My ref: FR/24-000164
Your ref: H19-0329-24
Date: 07/05/2024
Doc no: 201110598
Officer: Jessica Gething
E Mail: Jessica.Gething@cambridgeshire.gov.uk

Proposal: Temporary ground mounted solar photovoltaic (PV) farm with battery storage, substation and associated works.

Land East of Guanockgate Road Sutton St Edmund Spalding Lincolnshire PE13 4PL

Comments from Lead Local Flood Authority (LLFA)

Figure 7a: Surface Water Flow Routes and Mitigation Plan

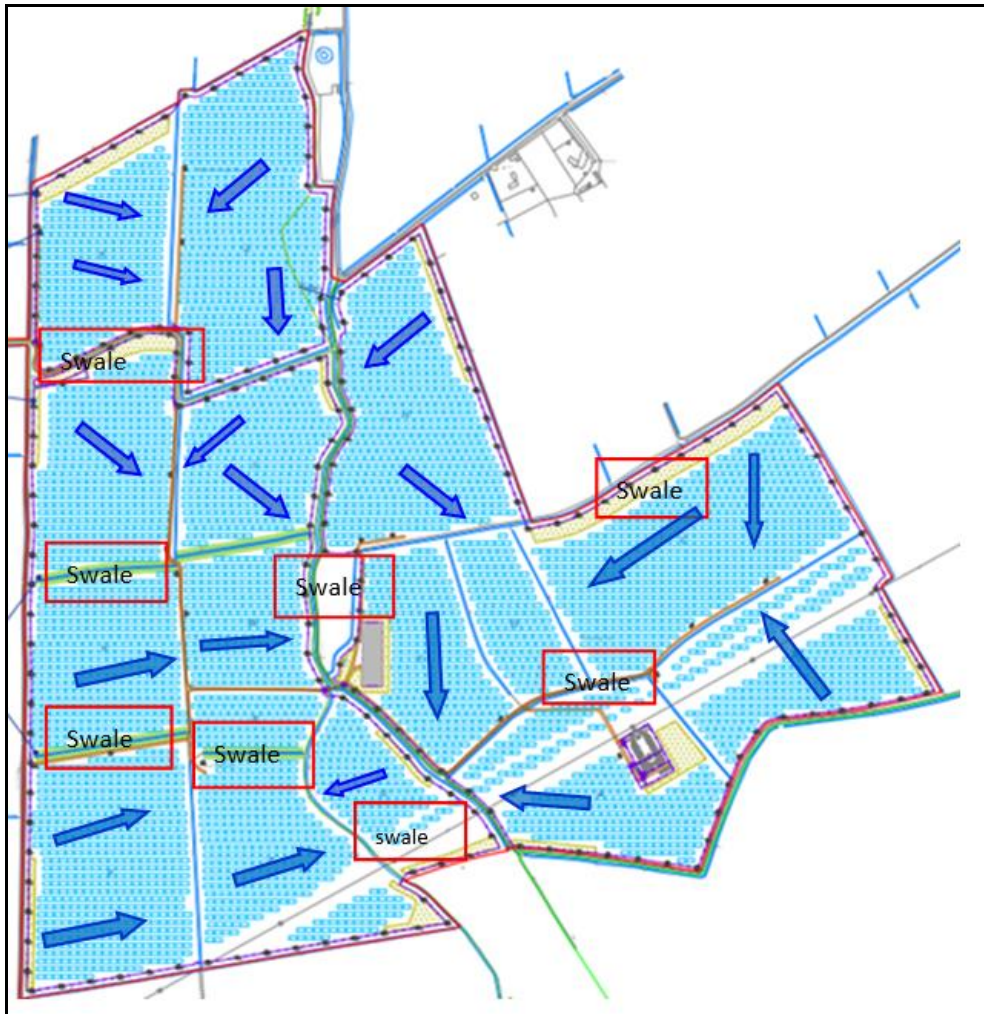
Whilst it is broadly accepted that solar farms do not respond in the same way as impermeable surfaces, they can lead to localised channelling of rainfall, particularly on sloping sites. This has the potential to increase flood risk downstream.

Options such as the inclusion of a French drains at the base of each row/ along access tracks to intercept flows and address water quality, inclusion of a swale(s) at the lowest parts of the site and designing panels with horizontal slots across the surface area should be considered as measures to manage surface water.
